Our ref: DOC21/823224-37

Your ref: SSD 23588910

**Request for advice – Environmental Impact Statement – Stage 1, North Tower, Central Coast Quarter, Gosford (SSD 23588910)**

**STEVE LEWER**  
**Acting Senior Team Leader Planning**  
**Hunter Central Coast Branch**  
**Biodiversity and Conservation Division**  
**Date:** 29 September 2021

DRAWING TITLE: **INTERNAL CIVIL WORKS STORMWATER MANAGEMENT & LEVELS PLAN GROUND**

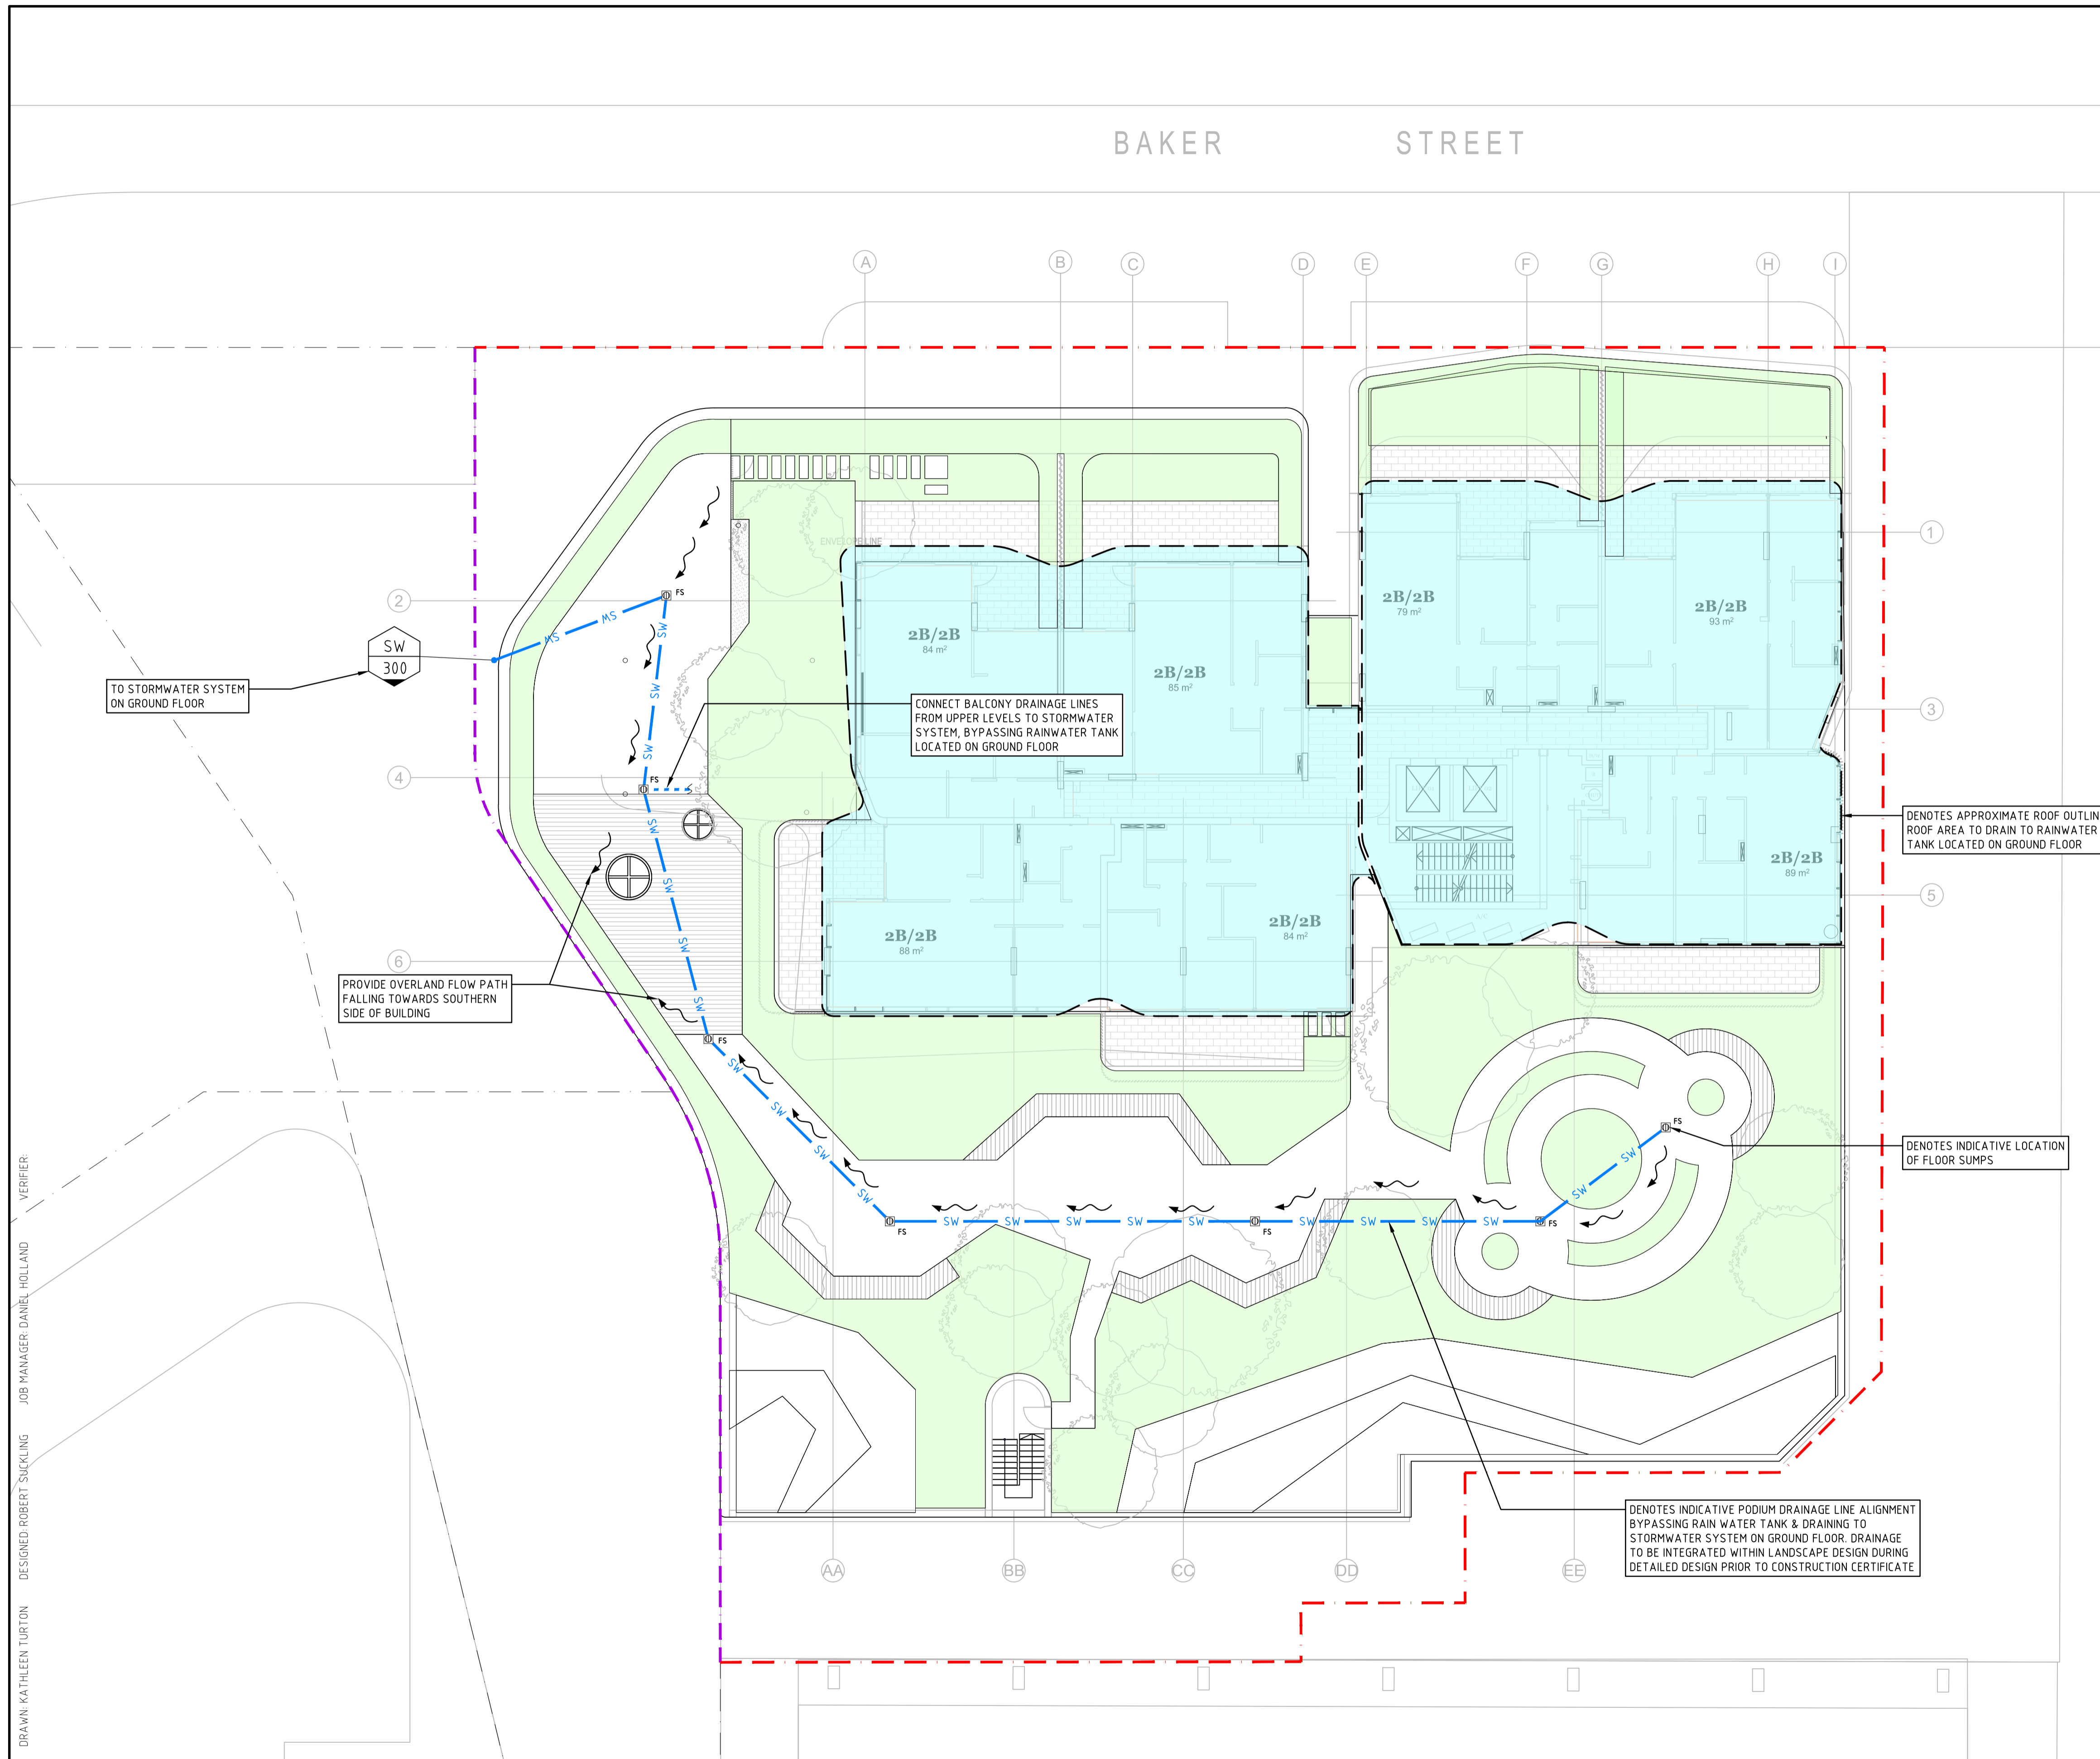
1. The performance of the proposed proprietary stormwater treatment devices has not been demonstrated.

It is proposed to use proprietary storm water treatment devices; SPEL Stormsack, SPEL Hydrosystem and Ecosol Storm Pit. However, the performance of these devices has not been documented. During the detailed design, the proprietary stormwater treatment devices will require independent testing to verify that they perform as claimed by the vendor.

2. Floodgates will need to operate without power.

It is proposed to use a concealed flood barrier on the Baker Street driveway to achieve the required flood immunity of 3.0m AHD. The Water Cycle Management Plan has not documented how the flood barrier will work during in a flood event.

3. The proposed flood protection barrier may prevent access to emergency service vehicles

During a flood event the Baker Street driveway flood protection barrier will activate. The flood barrier has the potential to block access to emergency service vehicles if there is a medical emergency during a flood event.

BCD recommends that the proprietary stormwater treatment devices are certified by an independent suitably qualified person during the detailed design.

BCD recommends that during the detailed design, the proponent should demonstrate that the flood protection barrier is fully automatic and does not depend on people, power or pumps.

BCD recommends that the flood emergency response plan should address how a medical emergency will be managed during a flood event.
